**SSD-87041214, Corowa Battery Energy Storage System, 275 Whitehead Street, Corowa NSW, 2646;
Response to Environmental Impact Statement**

TfNSW has reviewed the Environmental Impact Statement (EIS) Revision 2, prepared by NGH and dated 06 March 2026, and the Traffic Impact Assessment (TIA), Reference: 1357 rep 260109, Revision B, dated 09 January 2026, prepared by Amber Organisation, as key documents for preparing this response.

**SSD-87041214, Corowa Battery Energy Storage System, 275 Whitehead Street, Corowa NSW, 2646;
Response to Environmental Impact Statement**

Honour Avenue / Bullecourt Road Intersection

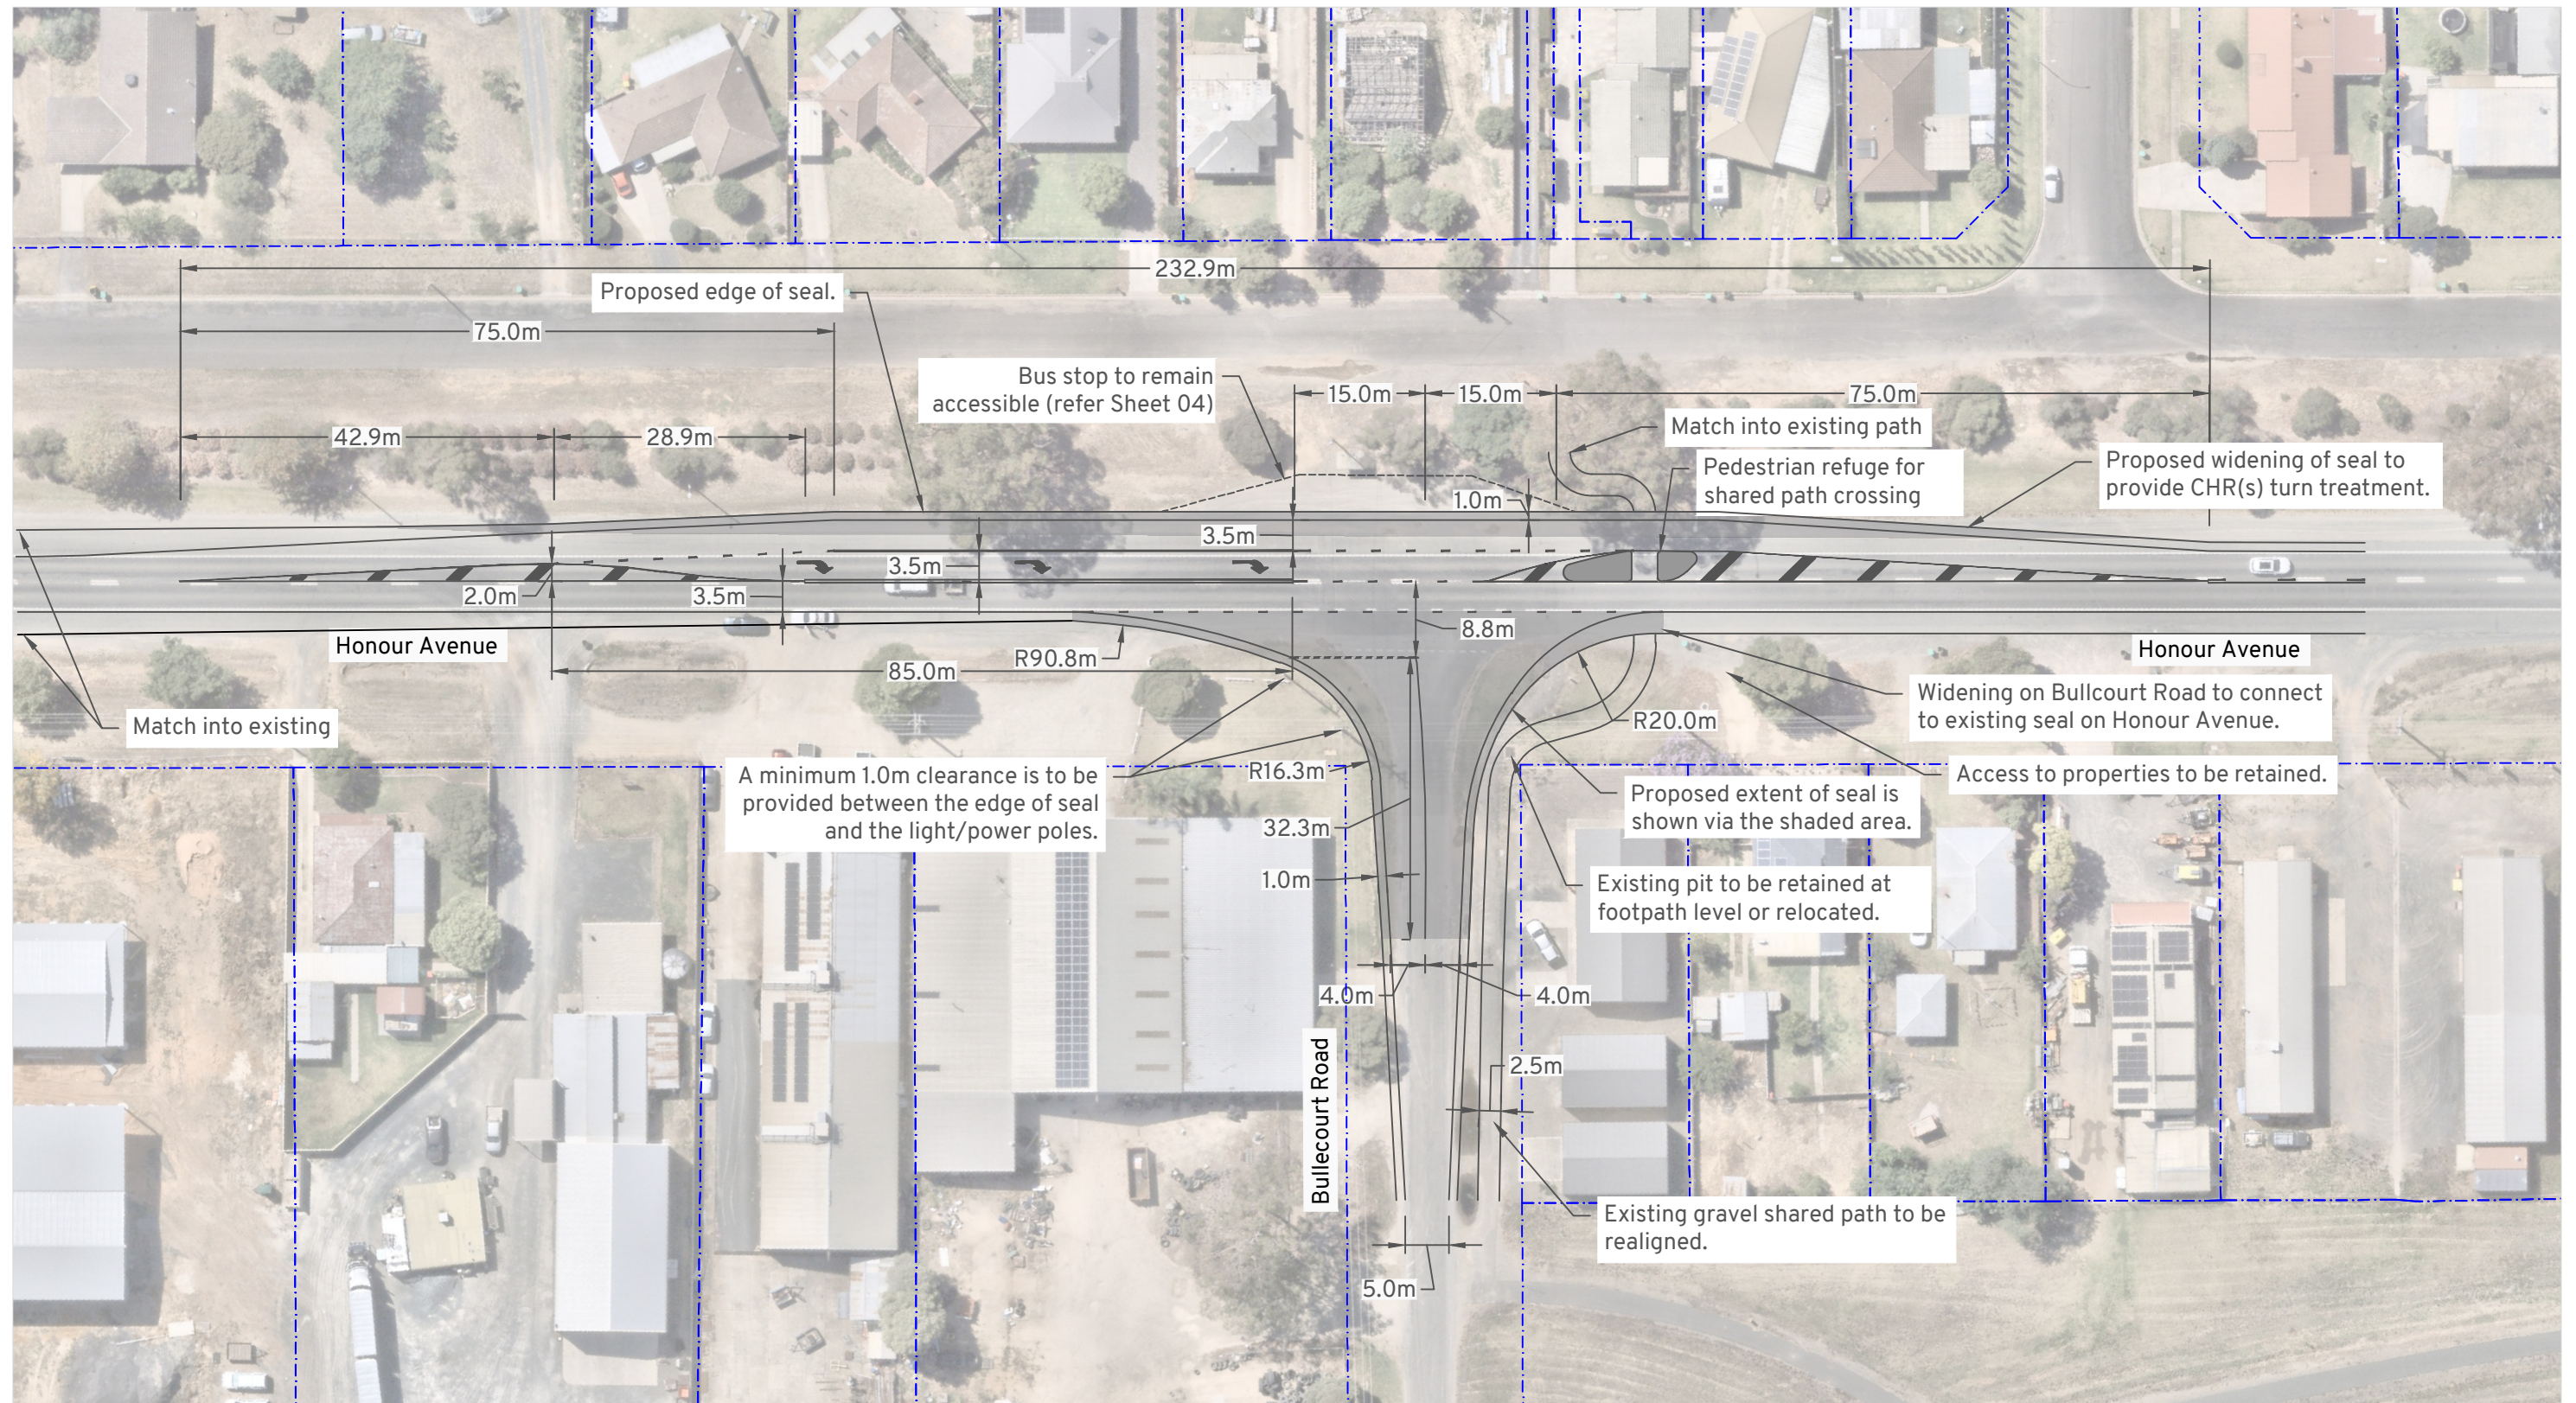
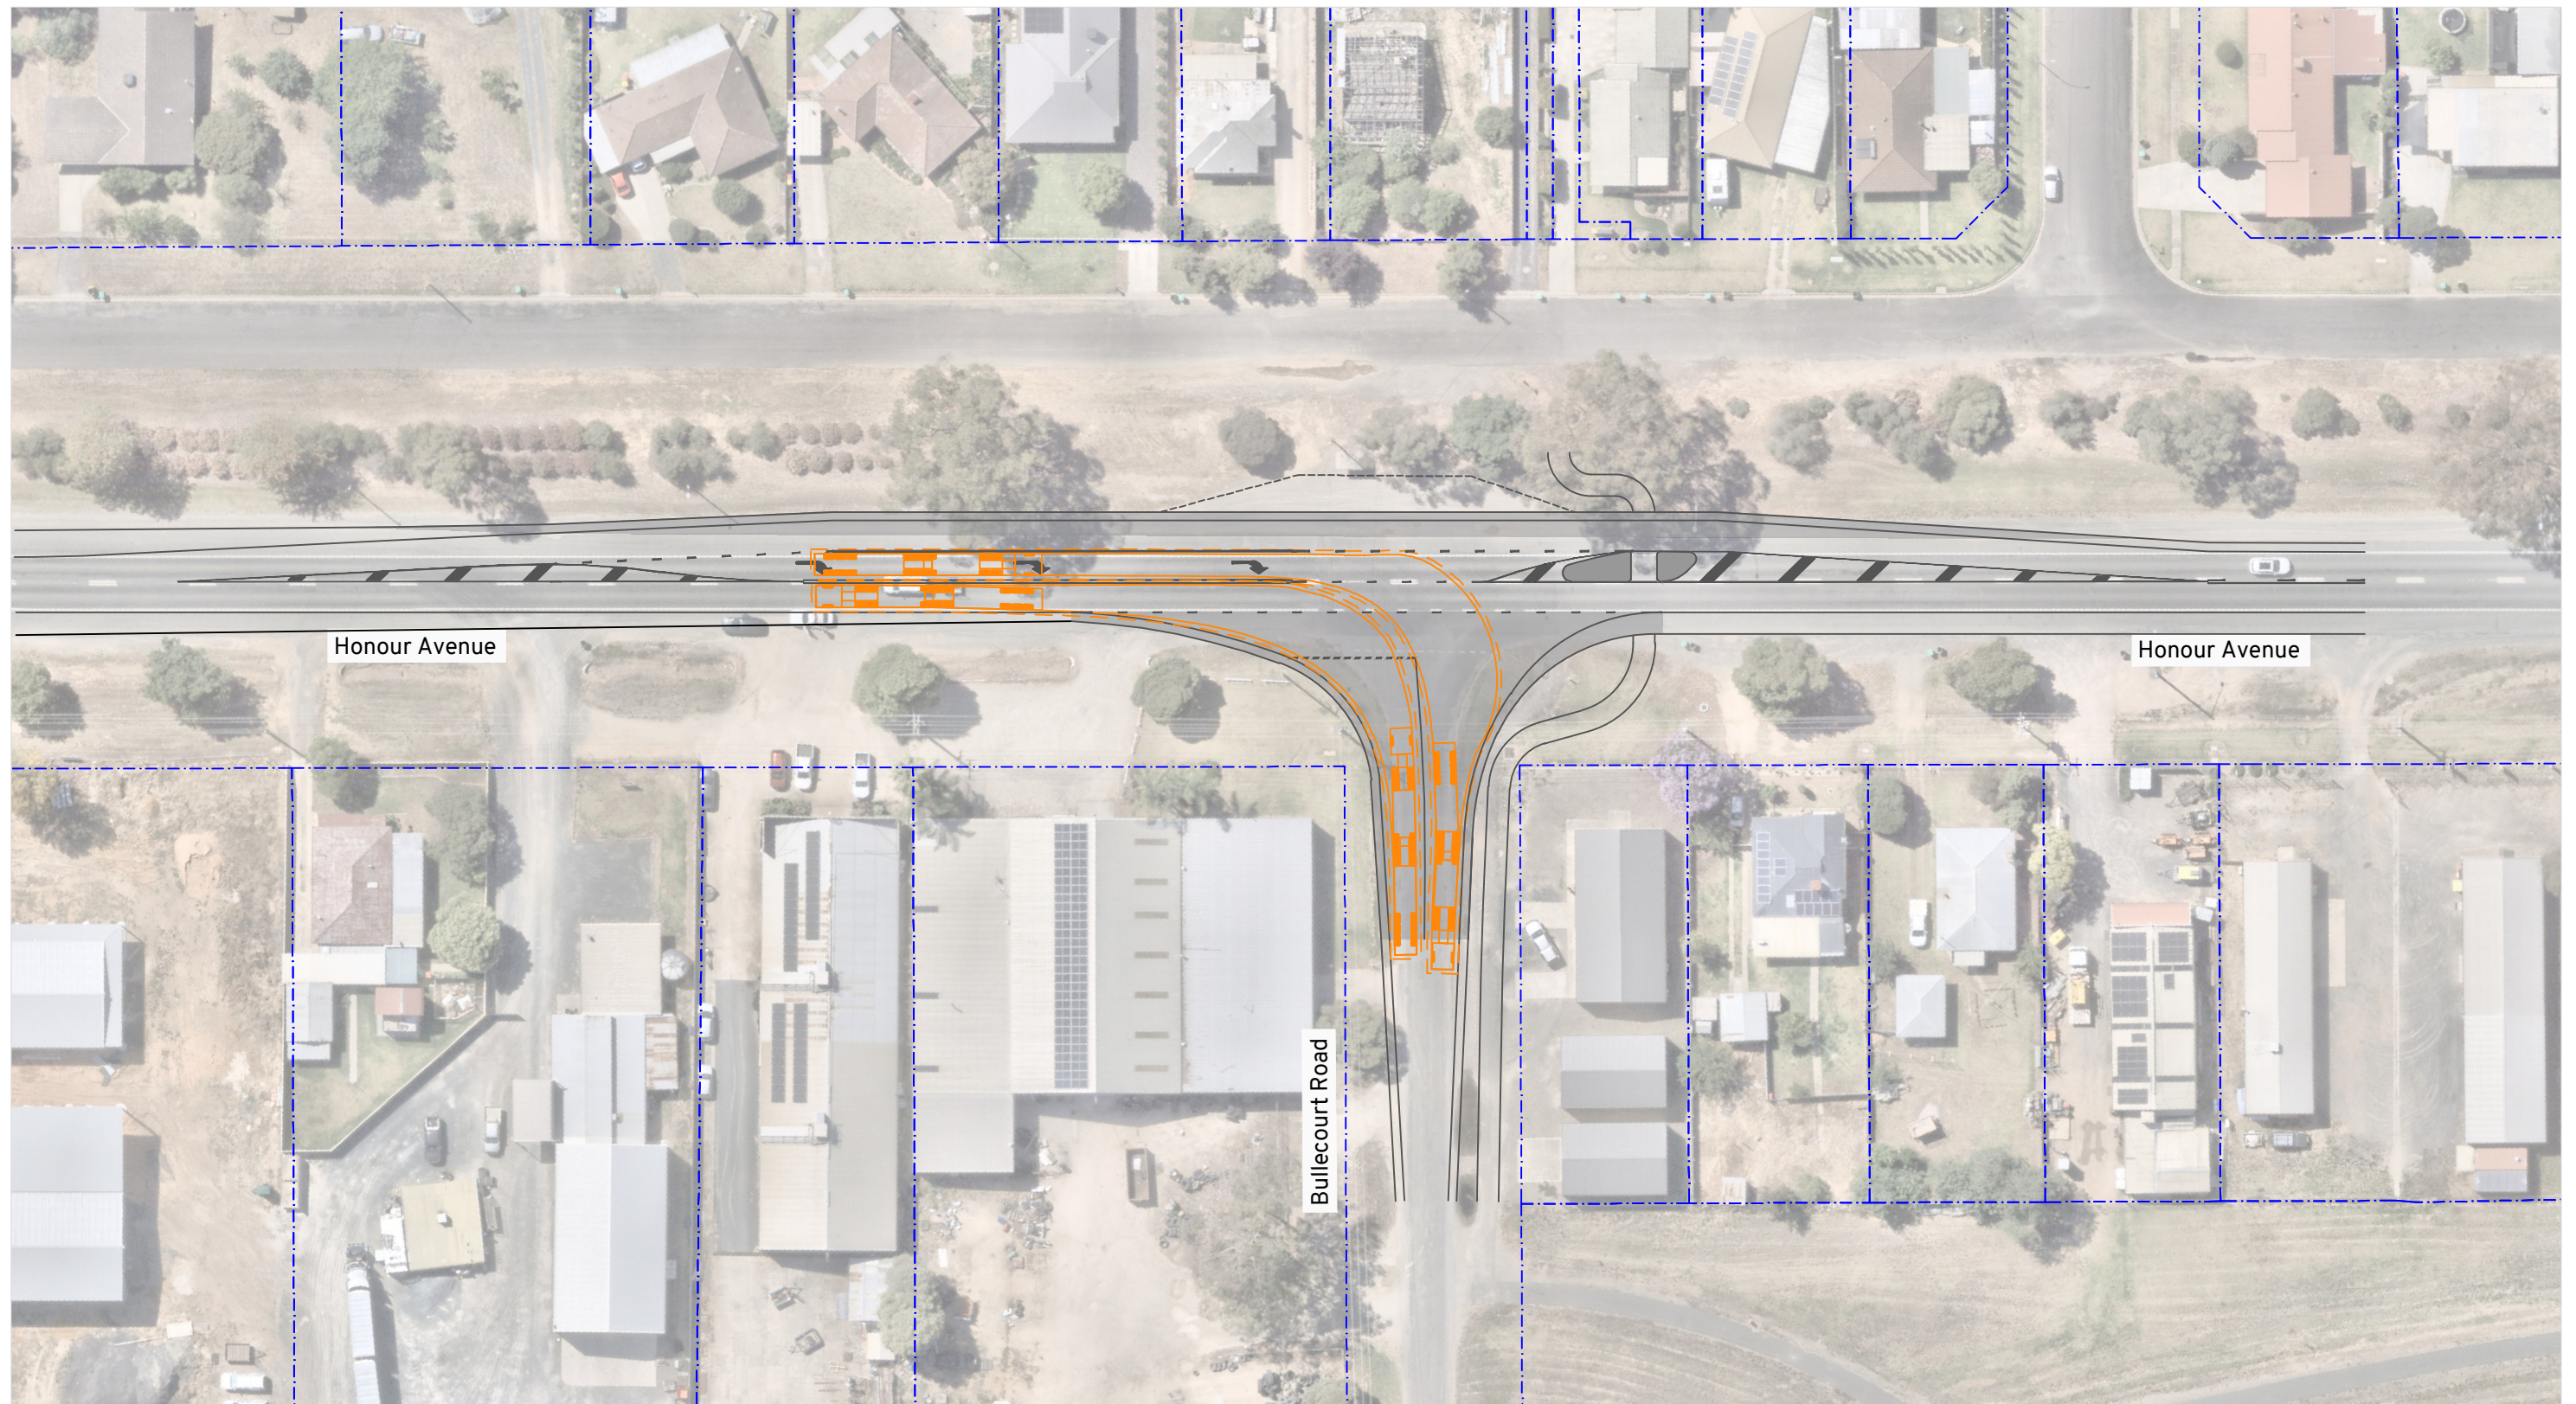
Strategic concept design required revisions and amendments			
1.	Sheet Reference: Amber 01	"Honour Ave and Bullecourt Road - CHRs / BAL: Remove continuity lines delineating the right turn lane through to departure chevron"	TIA update of the strategic concept design package.

Sheet Reference: Amber 01	"Honour Ave and Bullecourt Road - CHRs / BAL: There is existing kerb and channel located on the western intersection return. Does the design intend to retain this?"

Sheet Reference: Amber 01	"Honour Ave and Bullecourt Road - CHRs / BAL: It appears that there is existing low spots with water ponding in this area. Please consider this in the next phase of the design"

Sheet Reference: Amber 01	"Honour Ave and Bullecourt Road - CHRs / BAL: The design proposes widening the intersection throat towards the power poles. Consider providing barrier kerb to protect road users from the poles to mitigate any potential utility strikes"

Sheet Reference: Amber 01	"Honour Ave and Bullecourt Road - CHRs / BAL: The design proposes to install a pedestrian refuge and intersection treatment. Please provide swept paths to confirm that existing accesses can still be maintained "

Sheet Reference: Amber 01	"Honour Ave and Bullecourt Road - CHRs / BAL: Please note a minimum of 0.5m verge will be required to be installed for this layout"

Sheet Reference: Amber 01	"Honour Ave and Bullecourt Road - CHRs / BAL: Provide right out B-Double swept paths"
Sheet Reference: Amber 01	"Honour Ave and Bullecourt Road - CHRs / BAL: Ensure that the raised pedestrian refuge achieves offset requirements for an 80km/h posted speed limit with flag lighting. "

Sheet Reference: Amber 01	"Honour Ave and Bullecourt Road - CHRs / BAL: Undertake a clear zone assessment - roadside safety evaluation to determine whether sufficient recovery space exists for errant vehicles and what actions are needed to mitigate roadside hazards as identified.

Sheet Reference: Amber 01	"Honour Ave and Bullecourt Road - CHRs / BAL: A BAL intersection treatment does not appear to have been provided. Required to be provided.
